# **Application by Highways England for an Order Granting Development Consent for A57 Link Roads**

## **The Examining Authority's third written questions and requests for information**

### **High Peak Borough Council's Response**

**6.4 Environmental Statement
Figure 5.1 Air Quality Constraints Map**

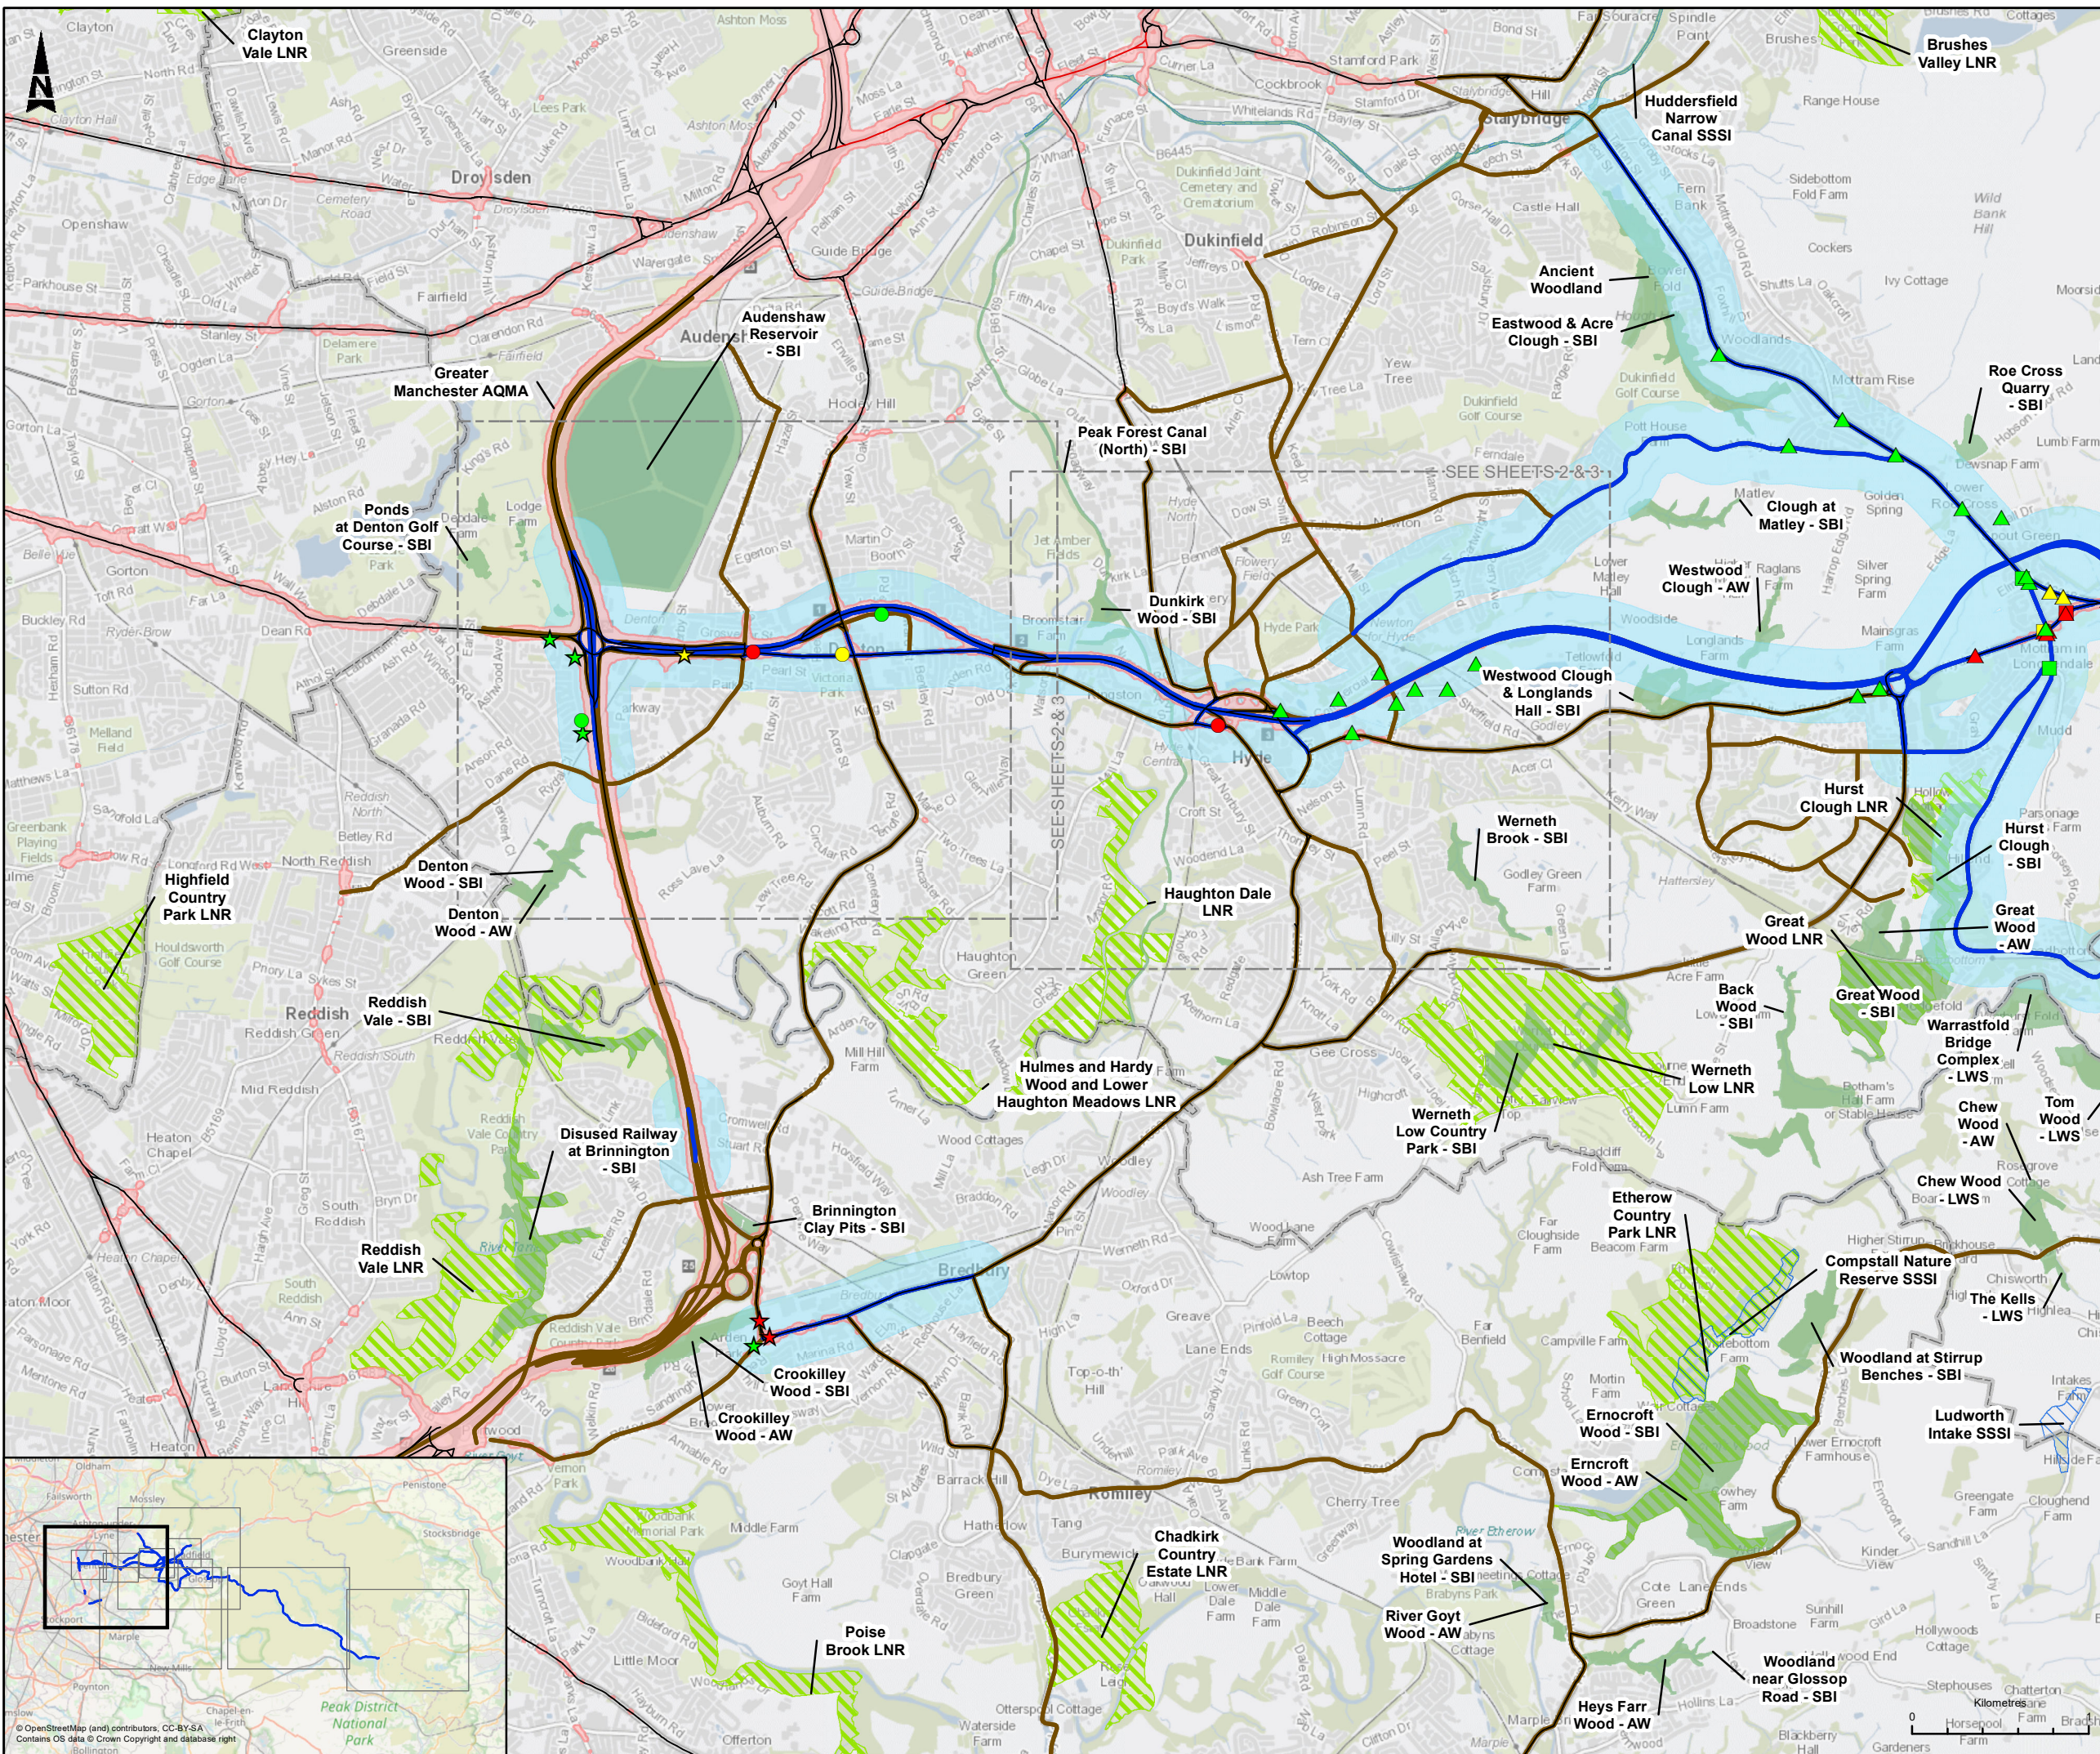
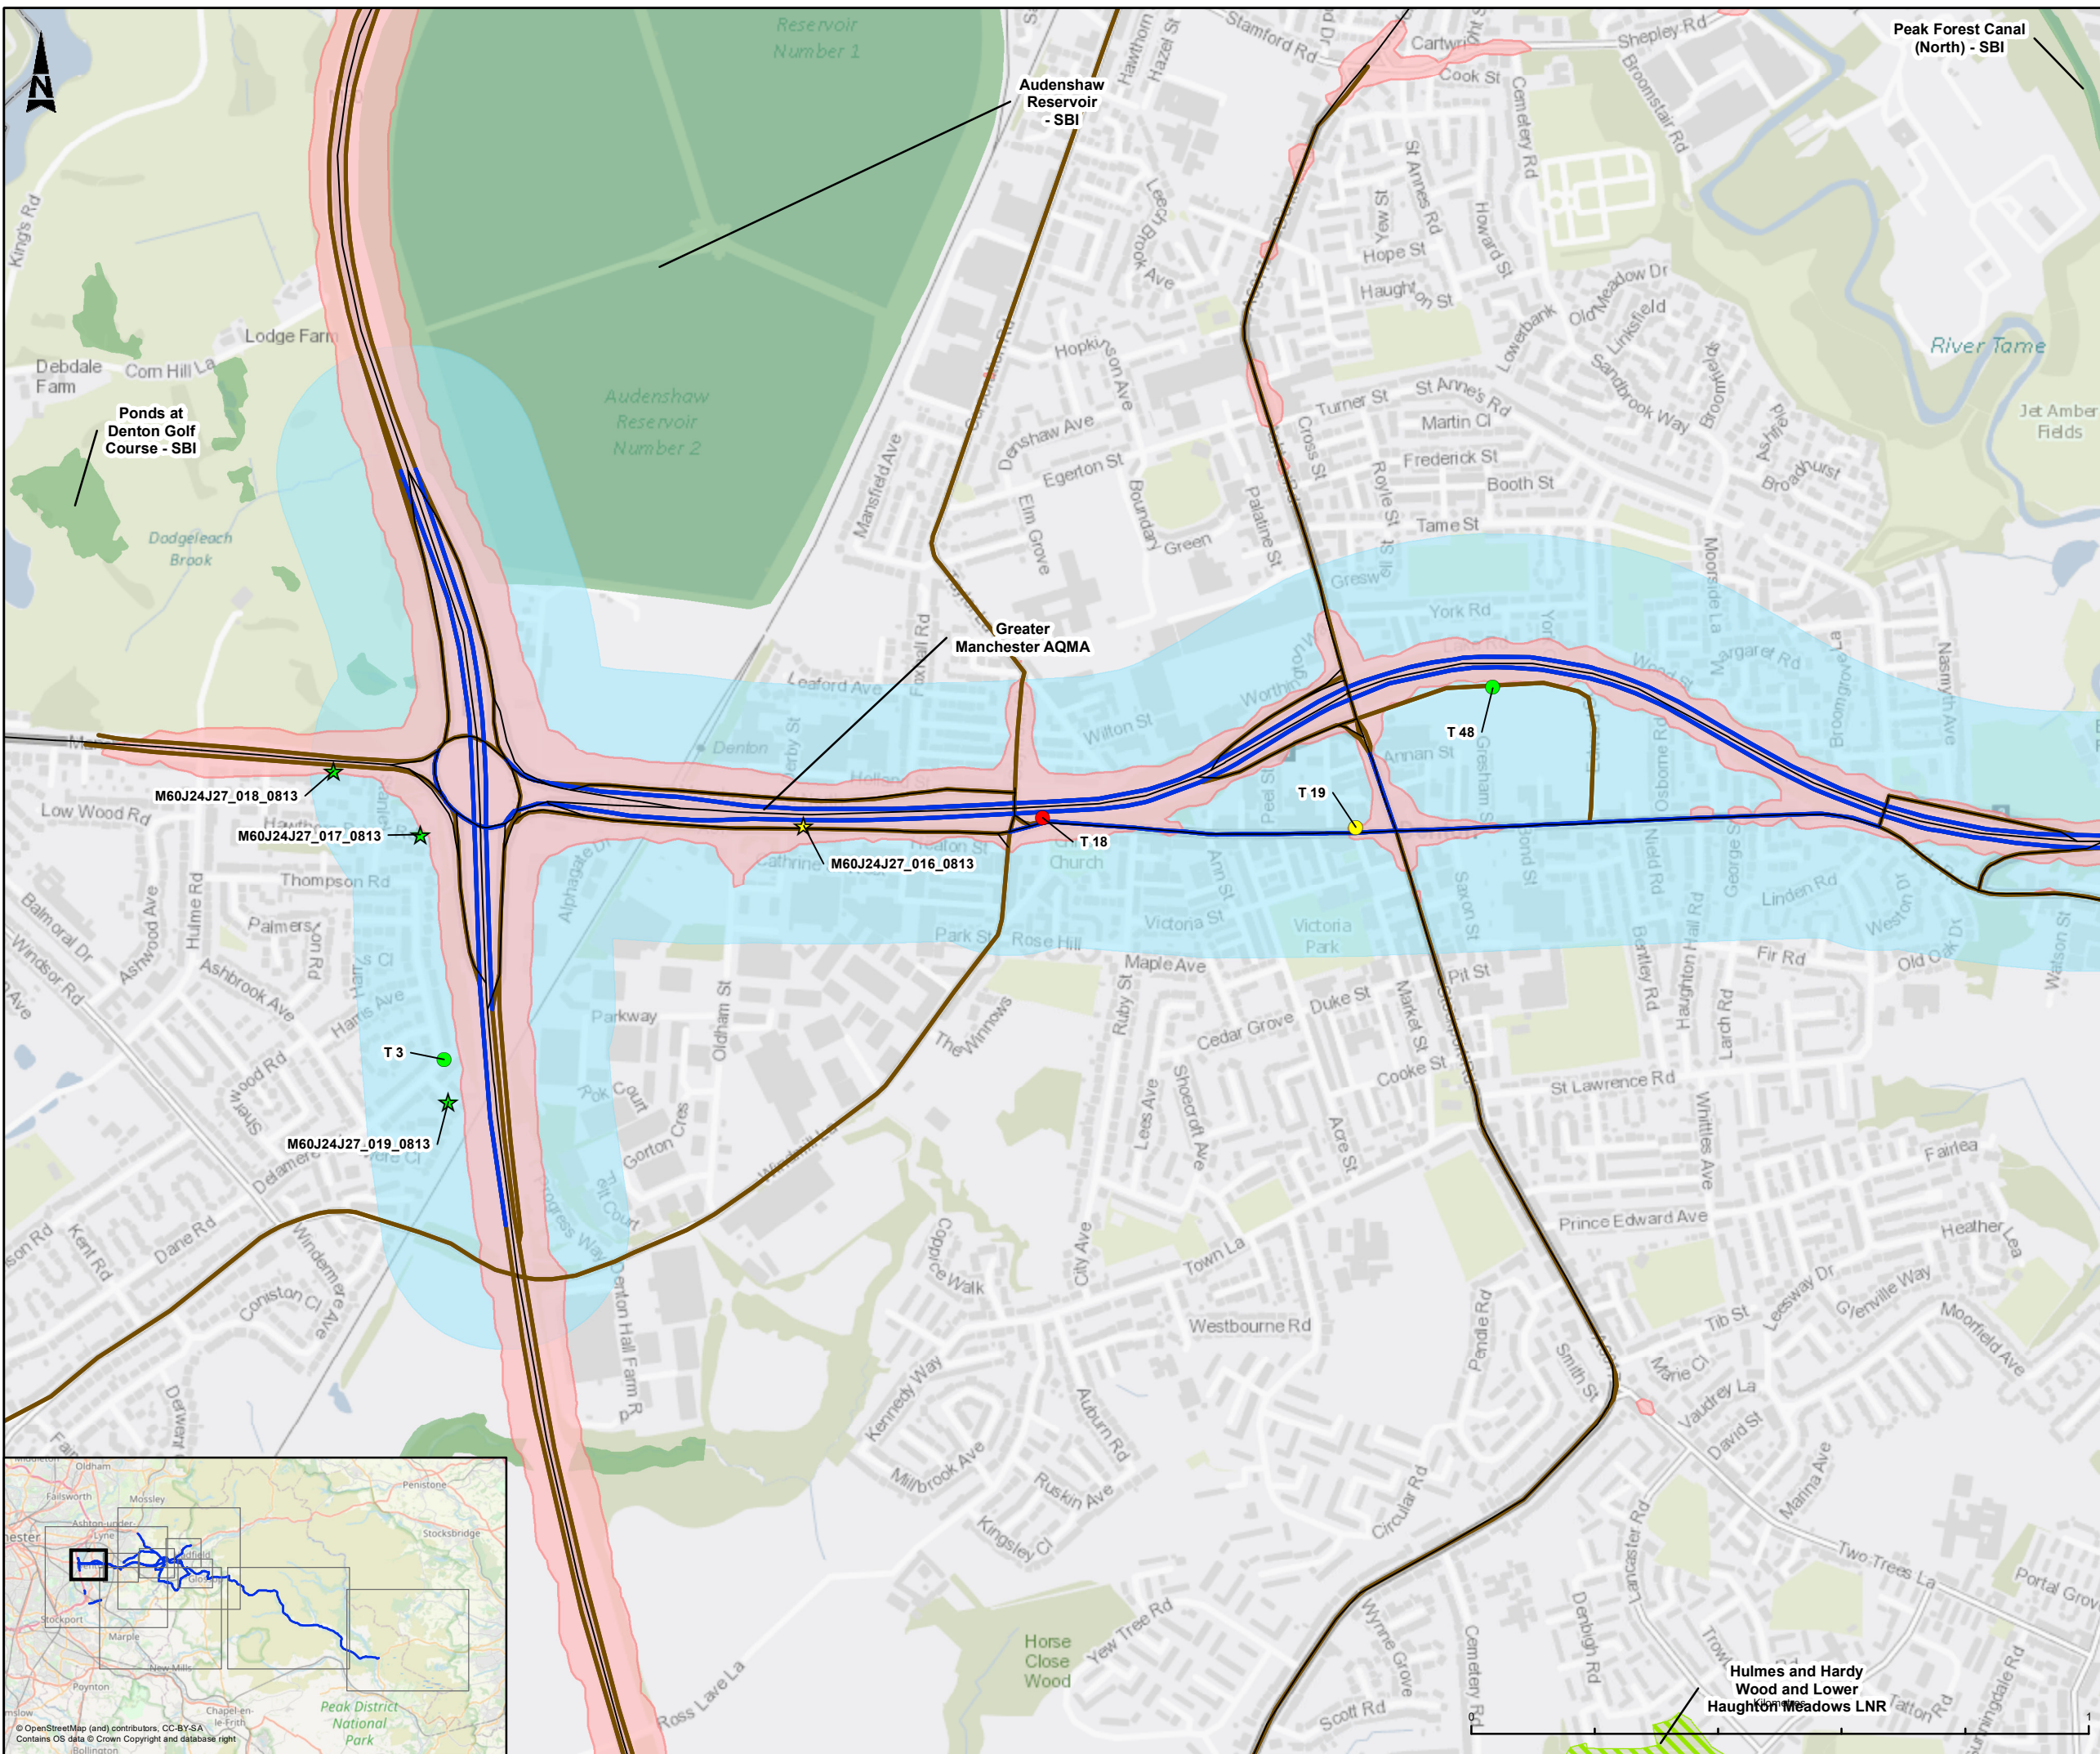
HPBC’s key concern remains that impact of the scheme on the designated AQMAs, should have been included on a precautionary basis;

However, as noted, there remains concerns over the accuracy of the traffic data that used to drive the scoping criteria, Notably, the changes in traffic numbers and/ or changes in speed bands.
